**STORMWATER MANAGEMENT PLAN
FOR
VOLLMER BABARICK SEGMENT
INTERIM ROADWAY IMPROVEMENTS**

JR Project No. 25188.00

July 2023

PCD Filing No.: CDR-21-10

VOLLMER ROAD (BARBARICK)
 -INTERIM CONDITION
 INITIAL/INTERIM GESC
 SHEET 2 OF 6
 JOB NO. 25188.01

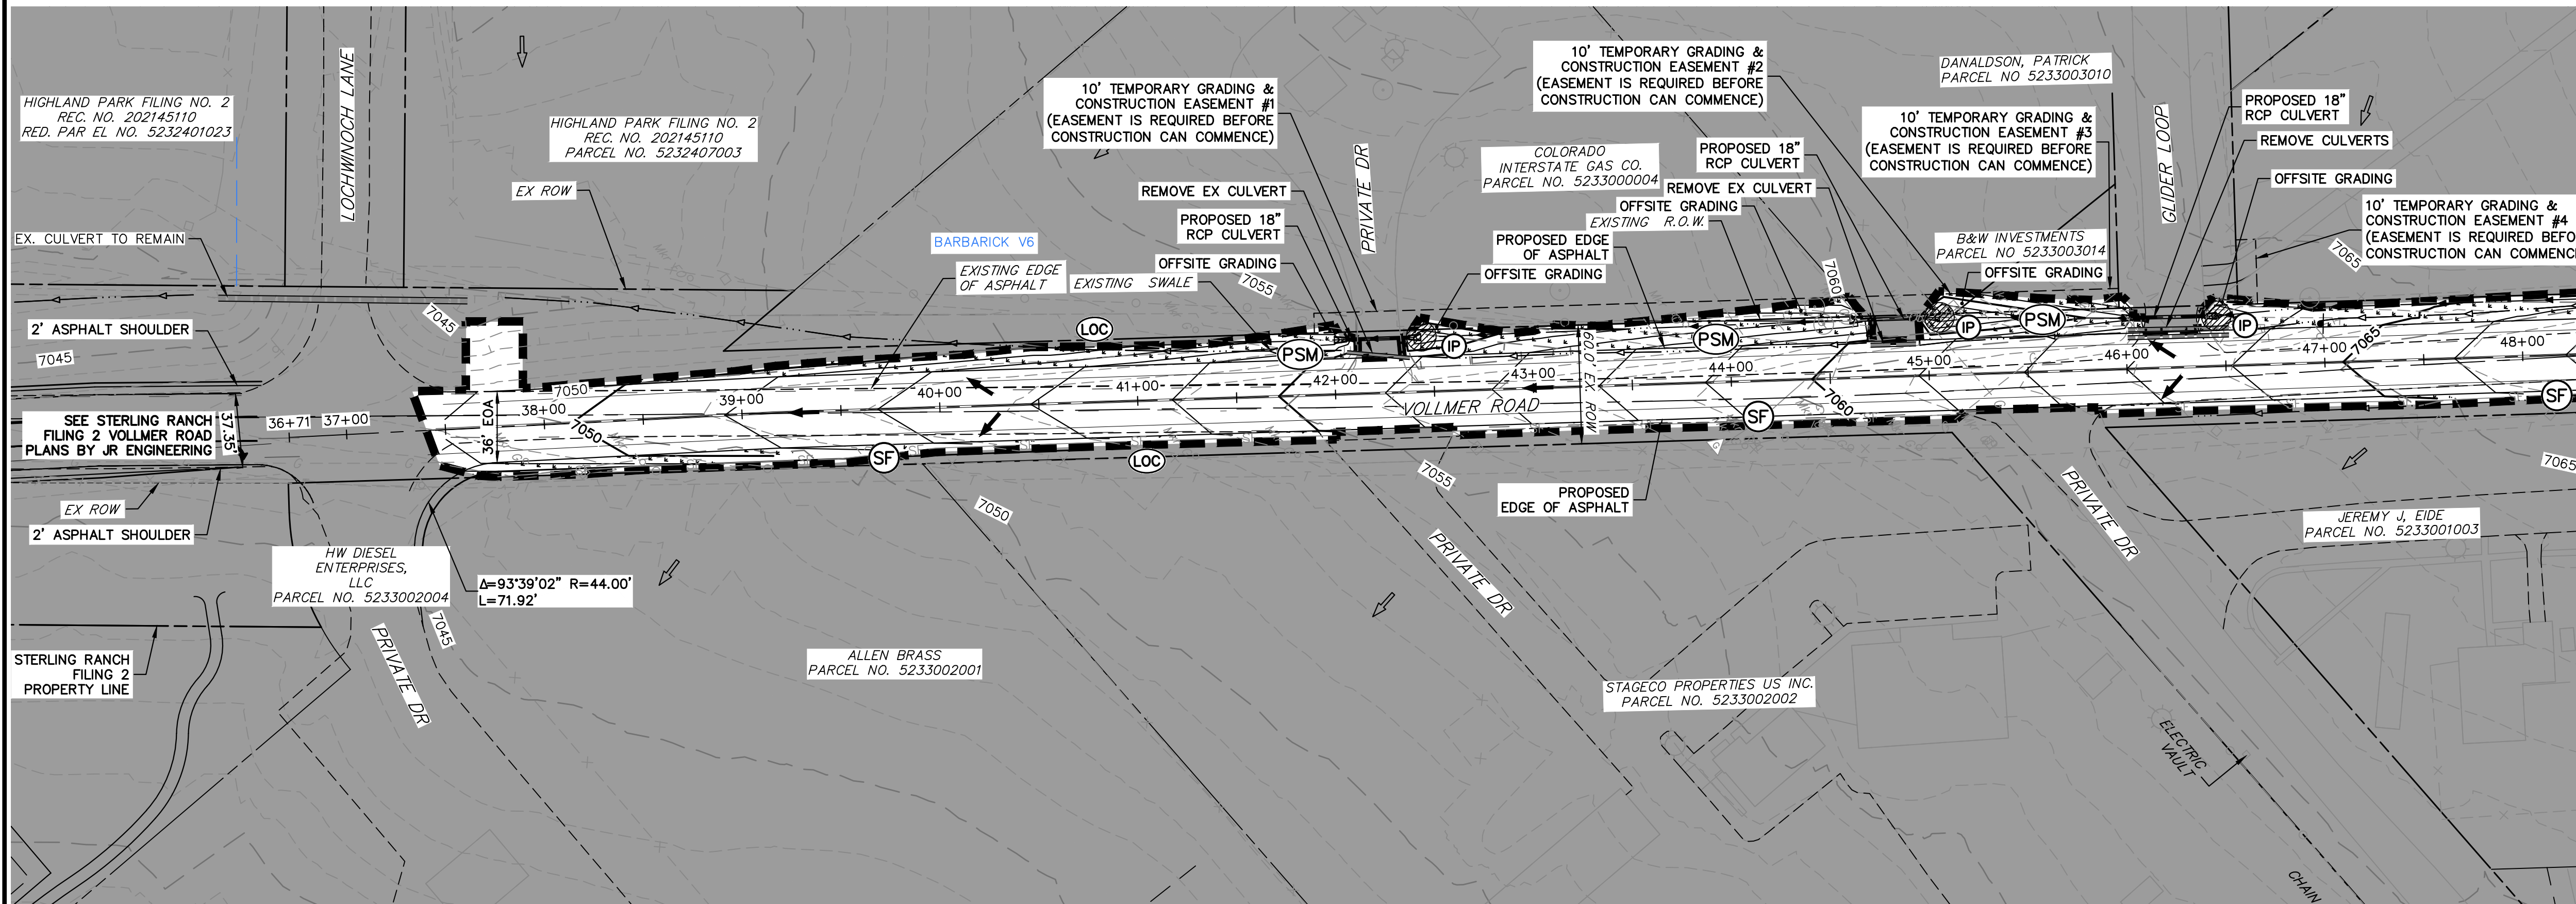
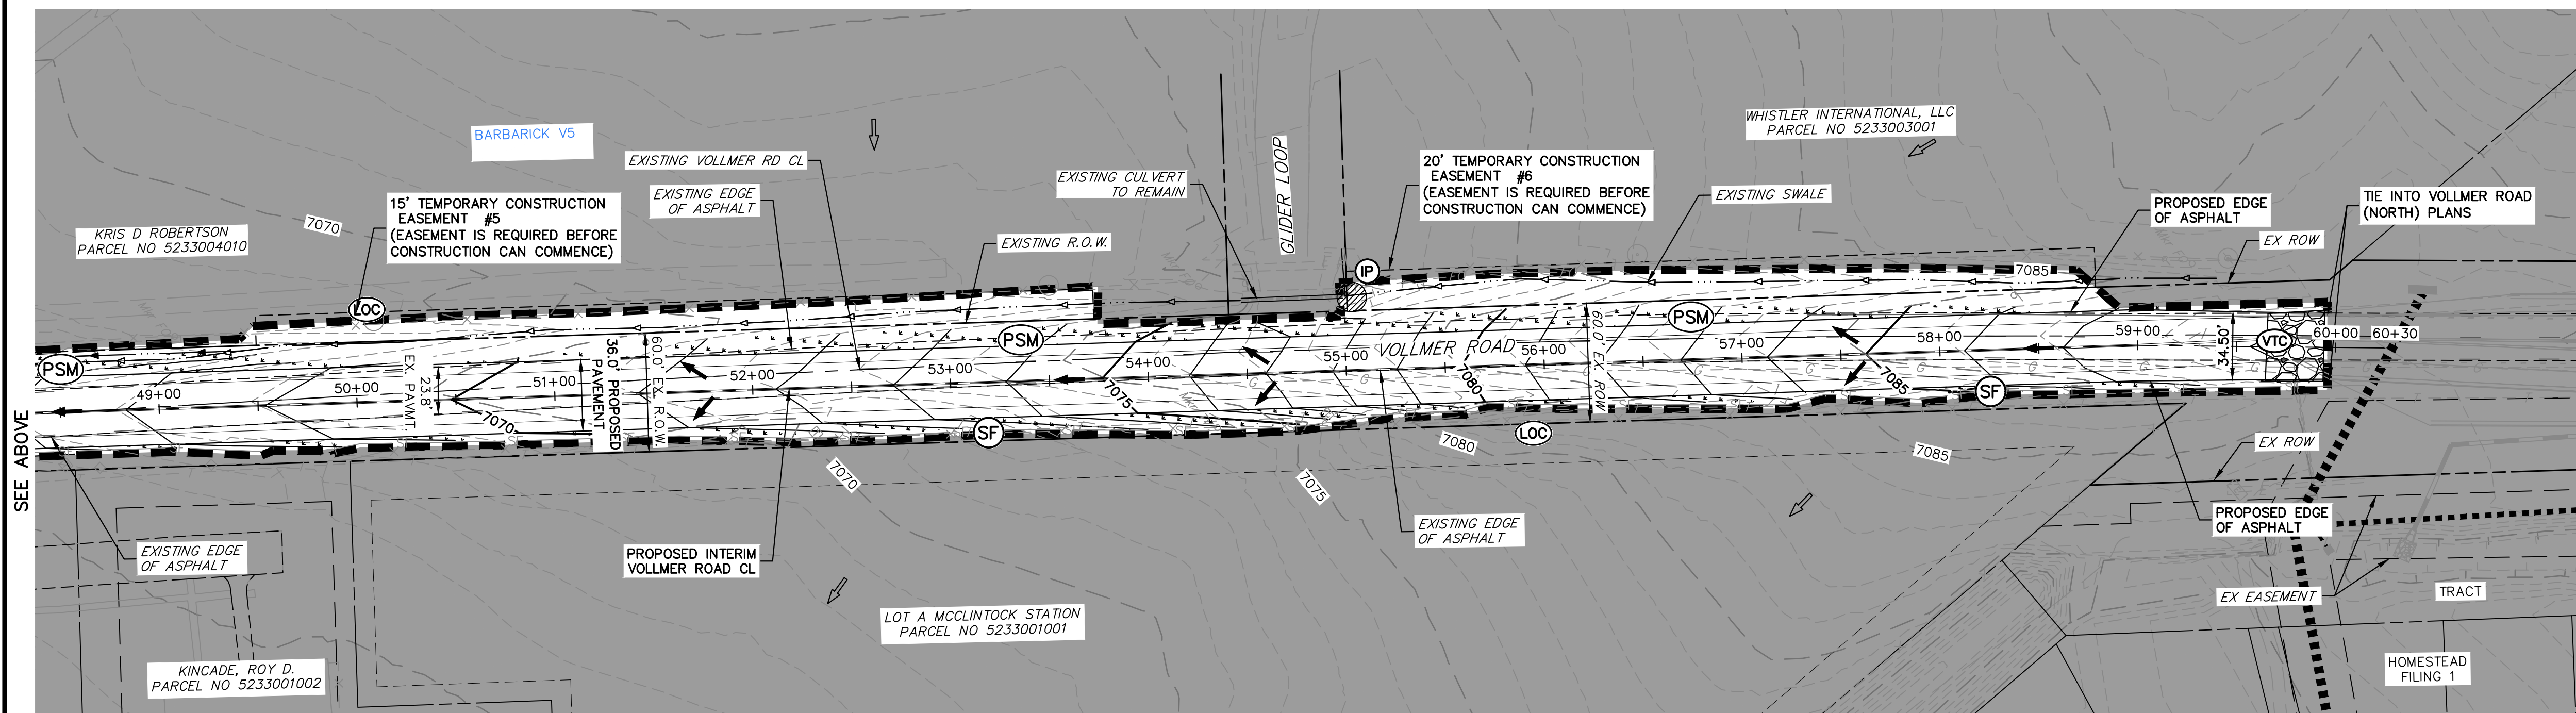
Unresolved from Submittal 1: % cover for vegetation refers to the percent of vegetal cover on the ground in the pervious regions of the site. Not the % of vegetation per the whole site. 30% still seems low. Looking on Google maps near the intersection of Vollmer Rd and Glider Loop the vegetation looks to be significant and higher than 30% ground cover. If the area has been disturbed recently, please use a nearby site that hasn't been disturbed to estimate the % vegetation.

JR Response: Addressed, text revised to 70%
